From: Simon Davis
Sent: 04 January 2019 15:07
To: Planning Scanning
Subject: FW: soakaway pipe work details BE/88/18/DOC

From: Laura Gibbons
Sent: 04 January 2019 14:22
To: Simon Davis [REDACTED]
Subject: RE: soakaway pipe work details BE/88/18/DOC

Scale: 1:100 No. 1891-1-102 B

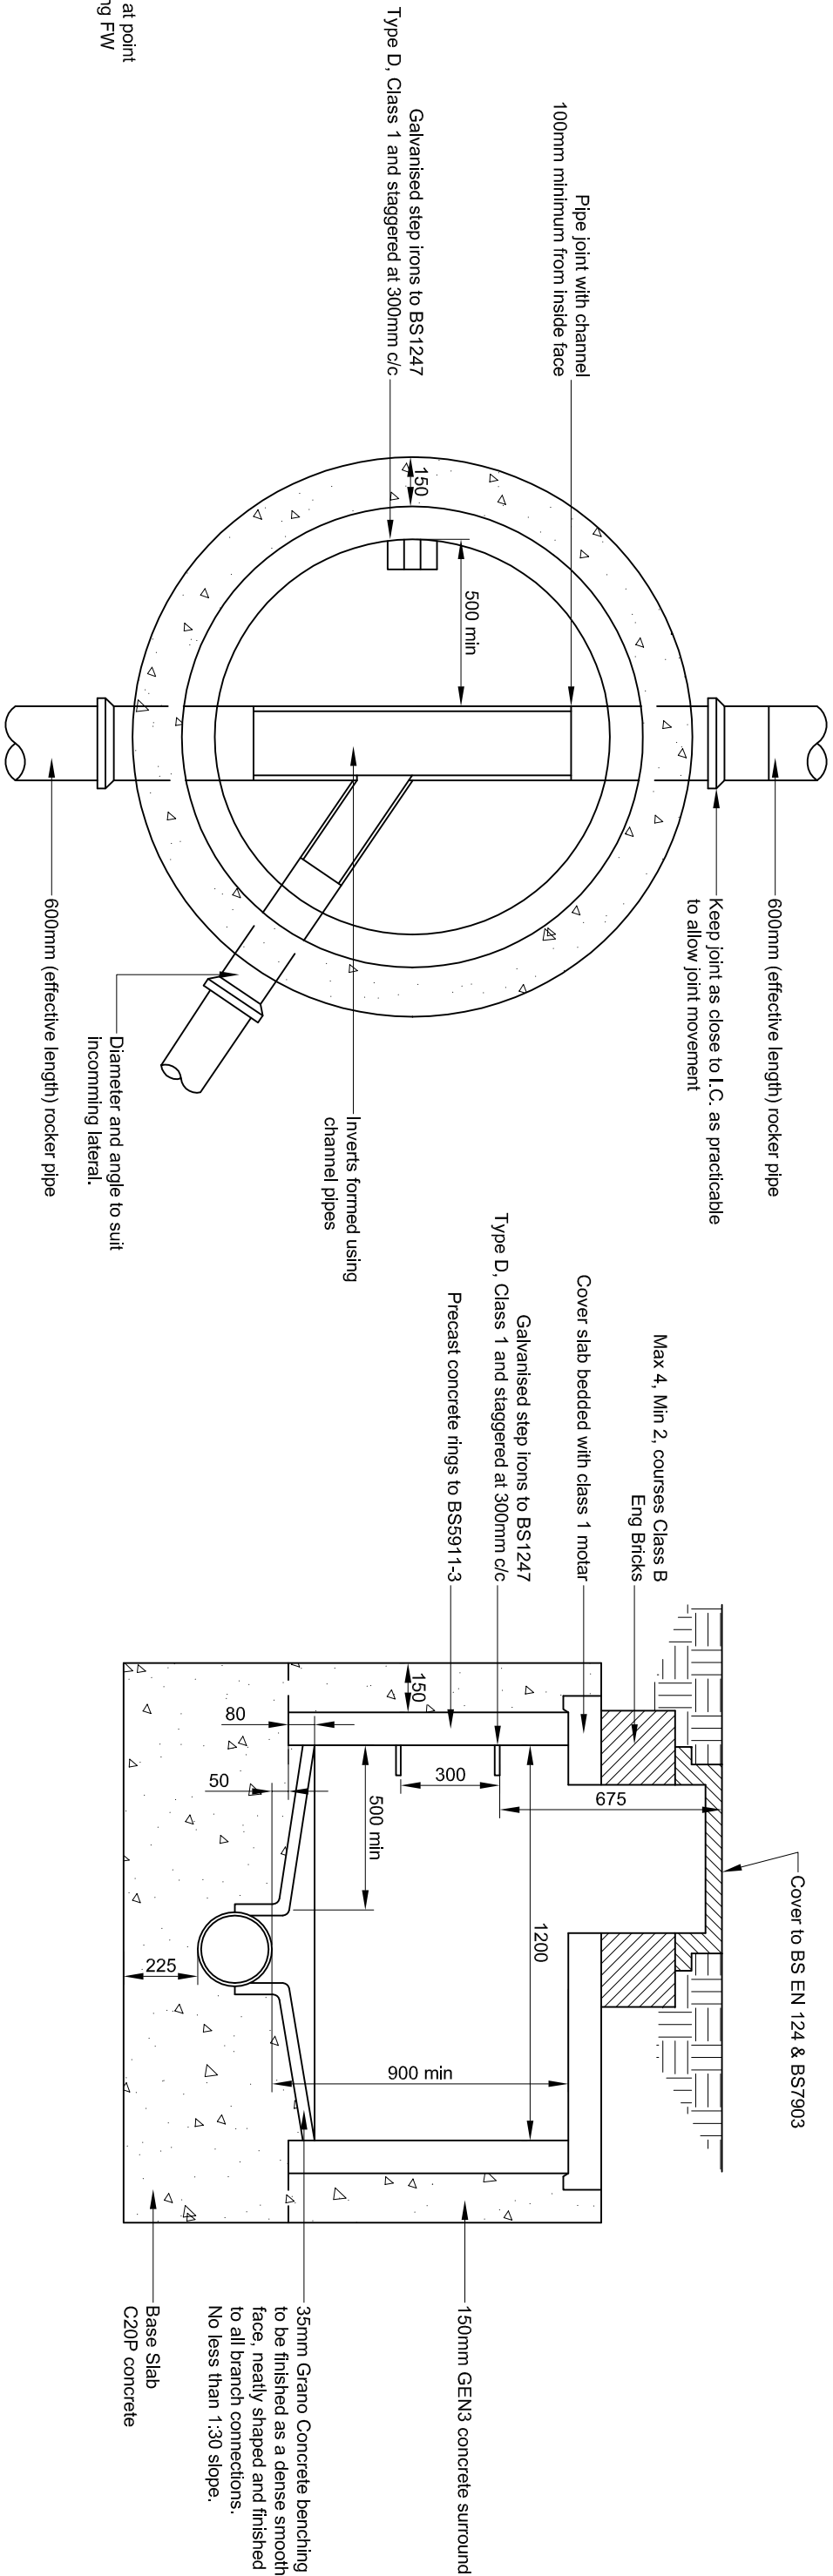
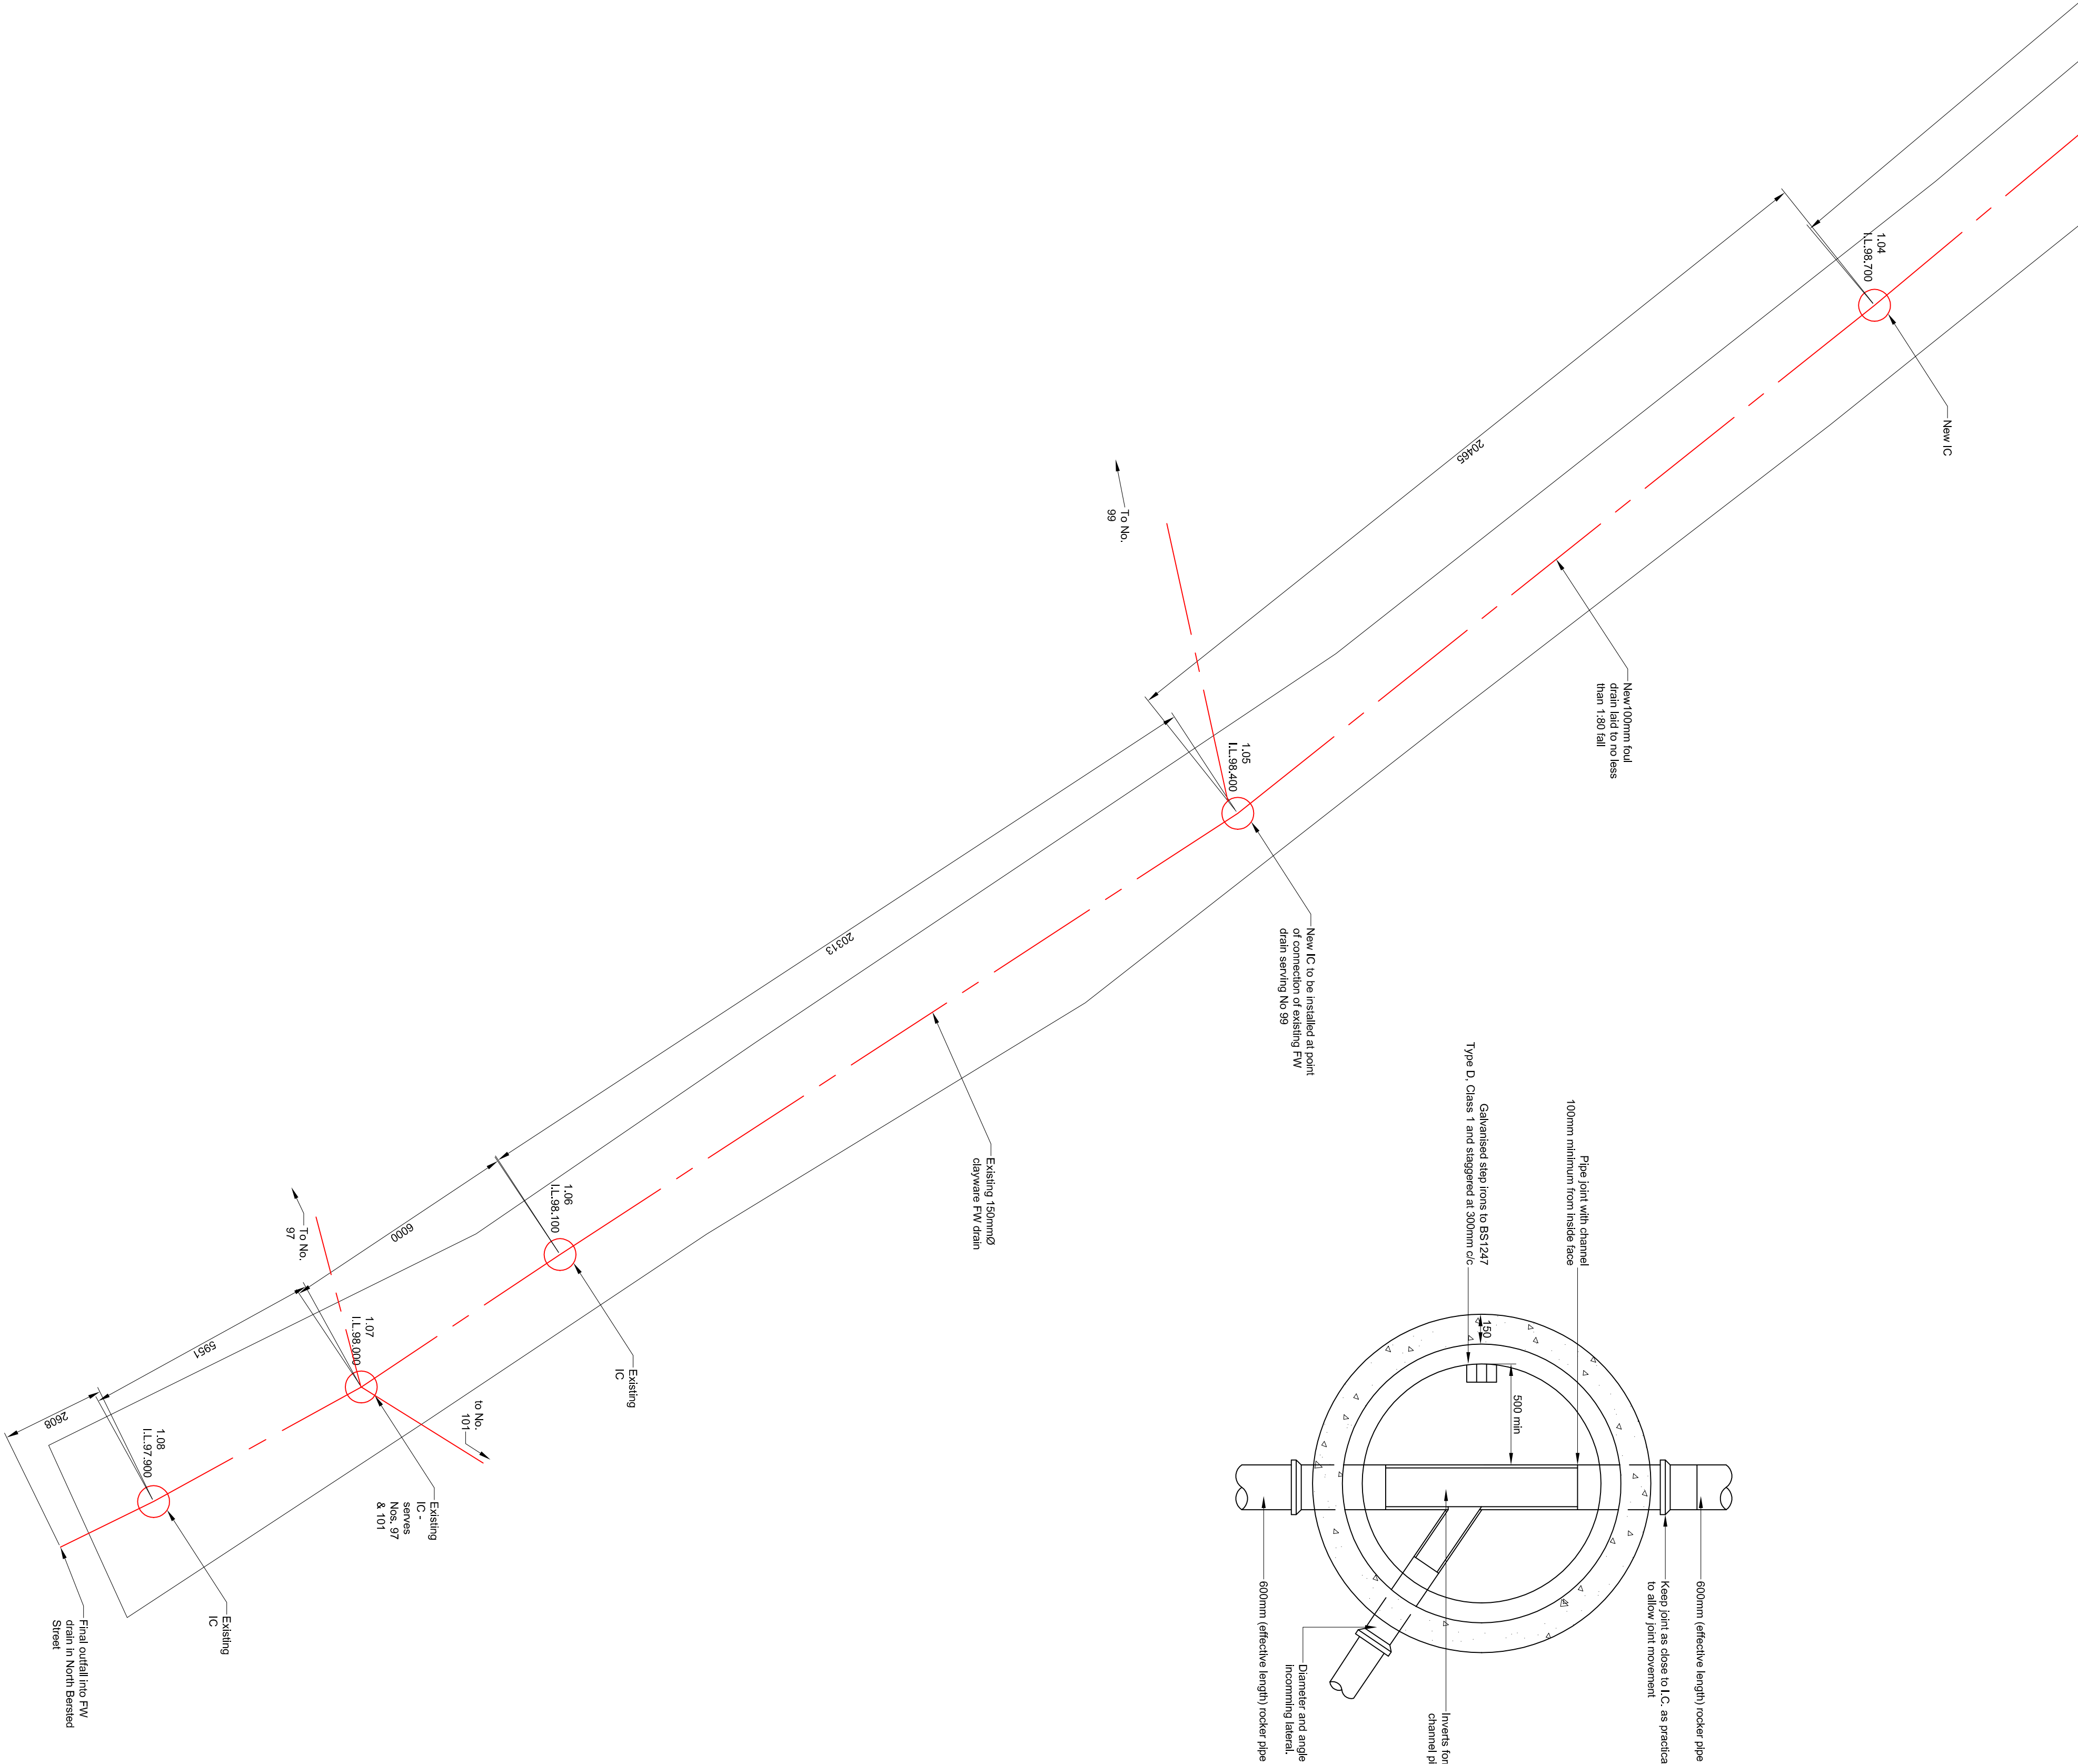
The drawing shows that the pipe bed and surround wouldn't meet our requirements. Please can the applicant ensure 150mm concrete bed and surround is provided. After this, I am happy with the proposals.

Hi Simon will change the drawing and send them back in.
